To: Charlotte Planning, Design & Development

Rezoning Petition #: 21-130

Proposed Zoning: UR-2 (CD)

Location of Property: Approximately 5.59 acres located on the west side of Rozzelles Ferry Rd and east of Clyde Dr, north of Bungalow Rd.

**RZ1.0**

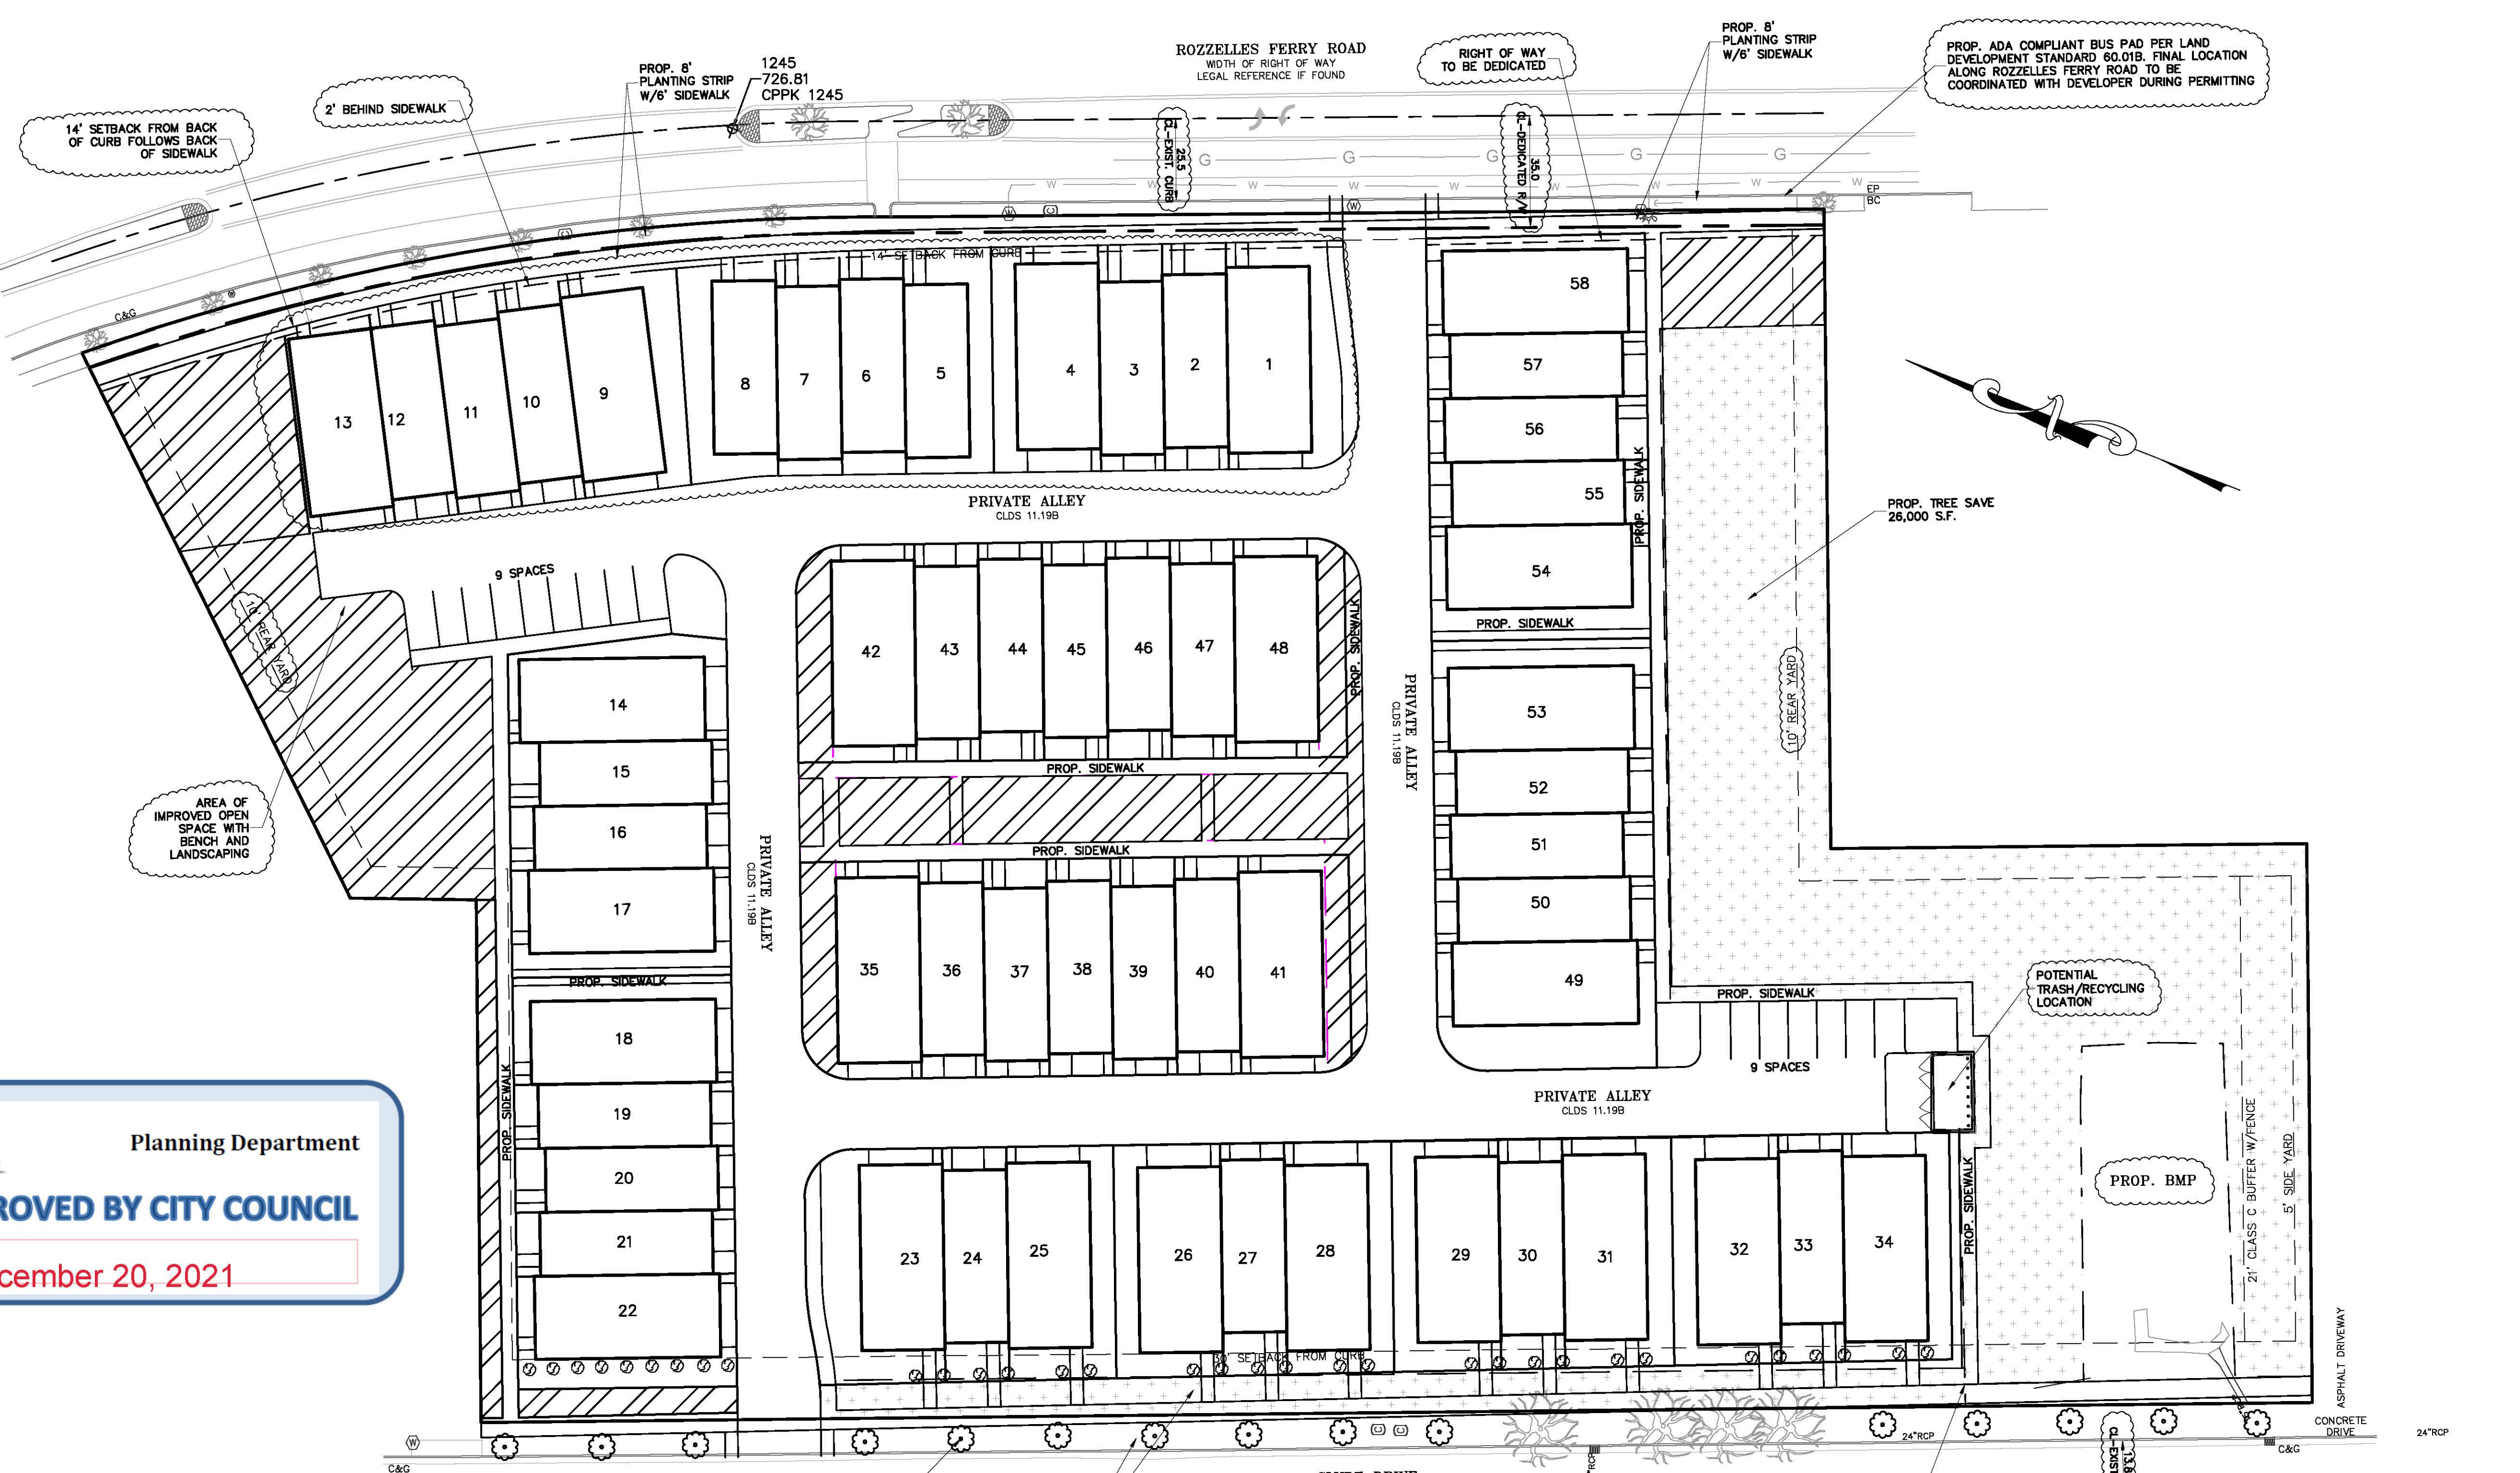
This property drains to the Irwin Creek, which is an impaired/degraded stream, and may contribute to downstream flooding. This project has the opportunity to mitigate future impacts to this stream, therefore, Storm Water recommends placing the following notes on the plan:

(I) Storm Water Quality Treatment

For defined watersheds greater than 24% built-upon area (BUA), construct water quality stormwater control measures (SCMs) designed for the runoff generated from the first 1-inch of rainfall for all new and redeveloped BUA associated with the project. SCMs must be designed and constructed in accordance with the Charlotte-Mecklenburg BMP Design Manual.

(II) Volume and Peak Control

For defined watersheds greater than 24% built-upon area, control the entire volume for the 1-year, 24-hour storm for all new and redeveloped BUA associated with the project. Runoff volume drawdown time shall be in accordance with the Charlotte-Mecklenburg BMP Design Manual.

For commercial projects with greater than 24% BUA, control the peak to not exceed the predevelopment runoff rates for the 10-yr, 6-hr storm and perform a downstream flood analysis to determine whether additional peak control is needed and if so, for what level of storm frequency, or if a downstream analysis is not performed, control the peak for the 10-yr and 25-yr, 6-hour storms.

For residential projects with greater than 24% BUA, control the peak to not exceed the predevelopment runoff rates for the 10-year and 25-year, 6-hour storms or perform a downstream analysis to determine whether peak control is needed, and if so, for what level of storm frequency.
